Application for a non-material amendment following a grant of planning permission.

Erection of a veterinary building -19/00171/F - 27.03.19

122807-001A - Floor Plans, Section & Elevations

South West Elevation

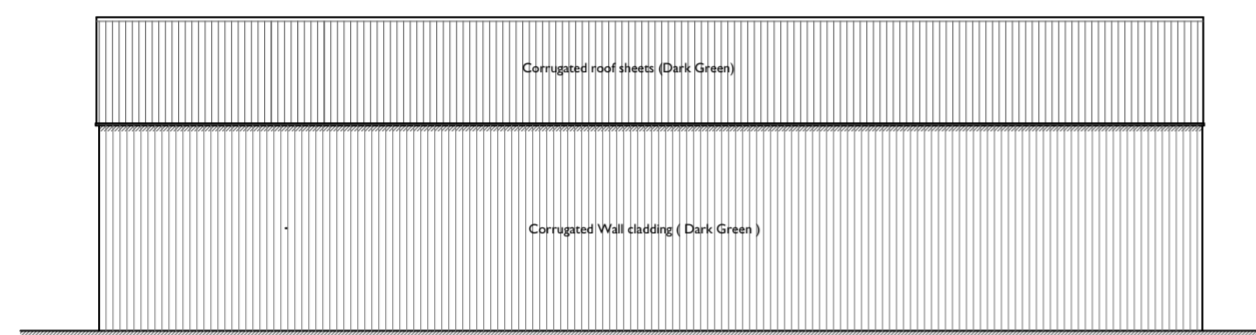
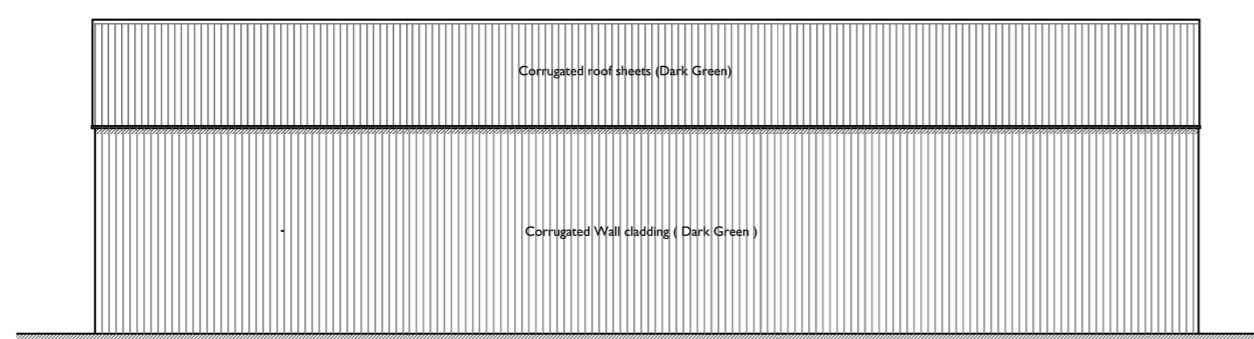
- added a shower room & made two larger WC's
- added a laundry, wash room & storage room
- swapped the vet's office with the store room
- added a window in the vet's office
- put treatment room 1 (T1) and 2 next to each other and increased their size
- added a larger rest room
- added 2 extra stables
- moved the personnel door on the SW elevation
- added stairs and first floor storage

The door has been moved for practical reasons.

Ground Floor Plan

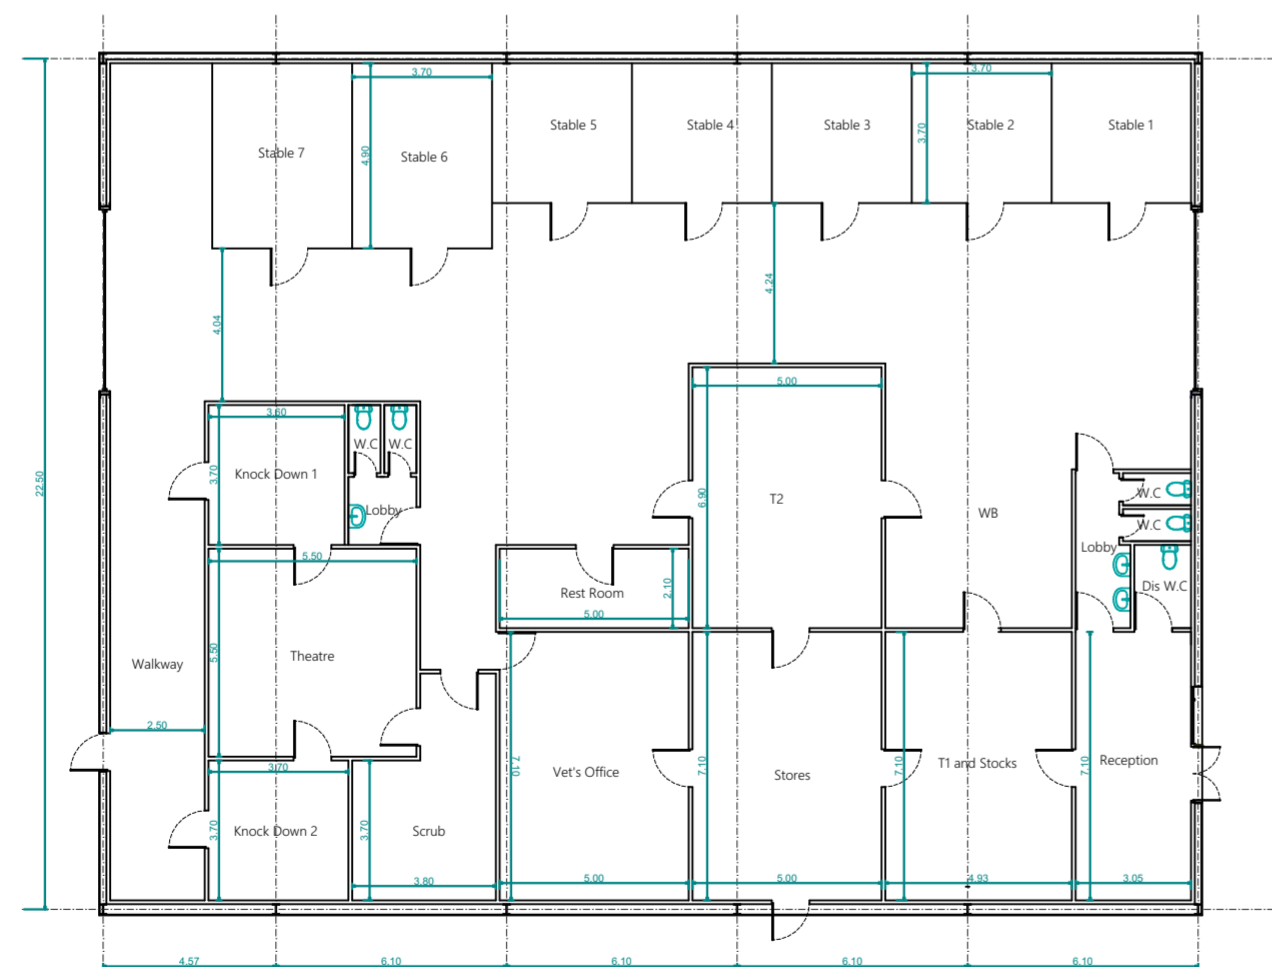
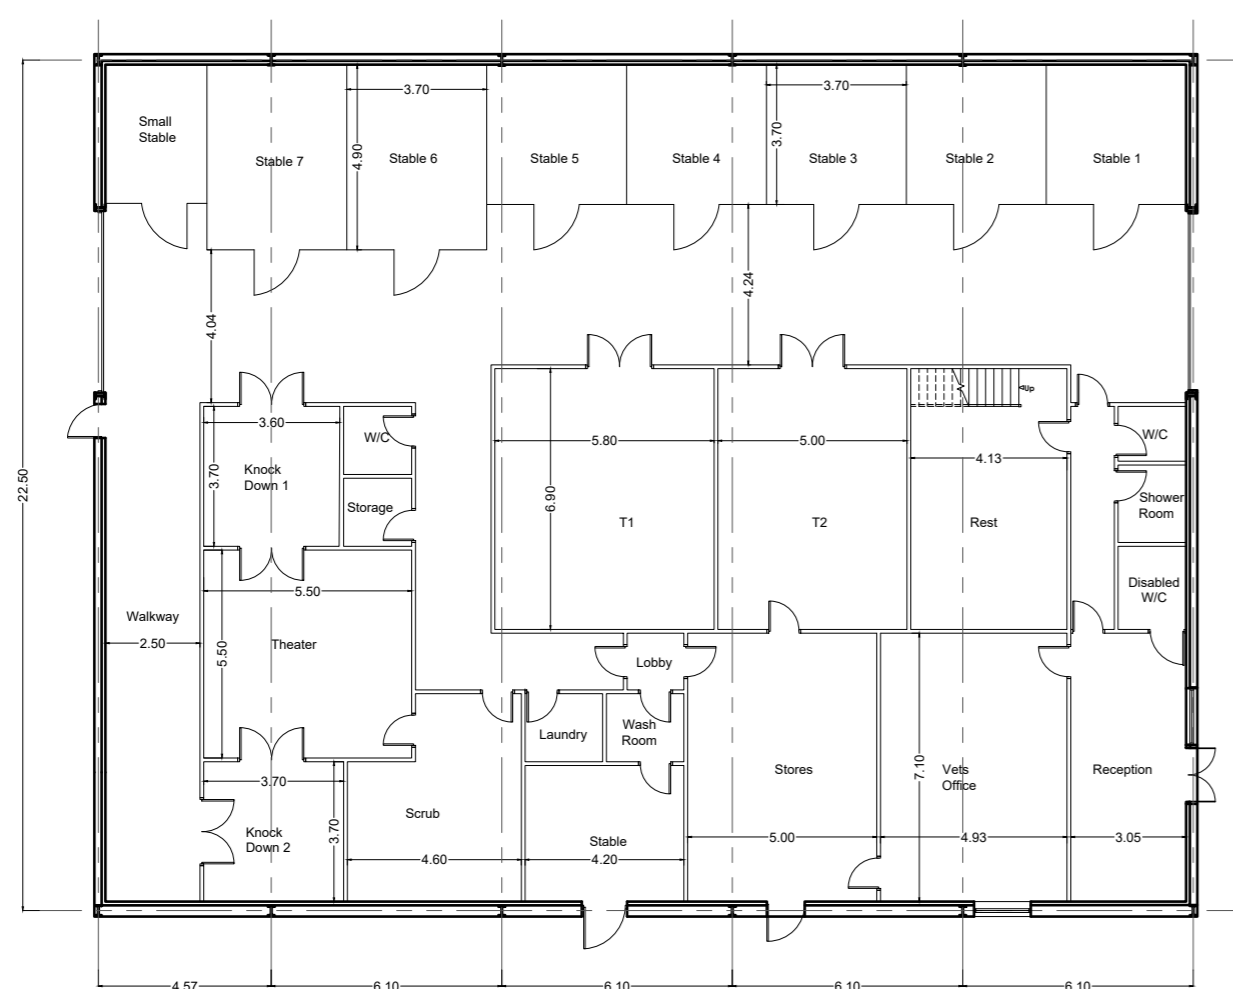
It makes more sense to situate the Vet's Office next to the Reception area, in case client's have a query. Not only this, it is now adjacent to the rest room. We are of the opinion that an office with natural light and air will create a much better working environment that one without.

The Treatment Rooms have been put next to each other and made larger for practical reasons. They have direct access to the walkway where horses will be lead into the building. They also need to house large stocks, which is why they have increased in size.
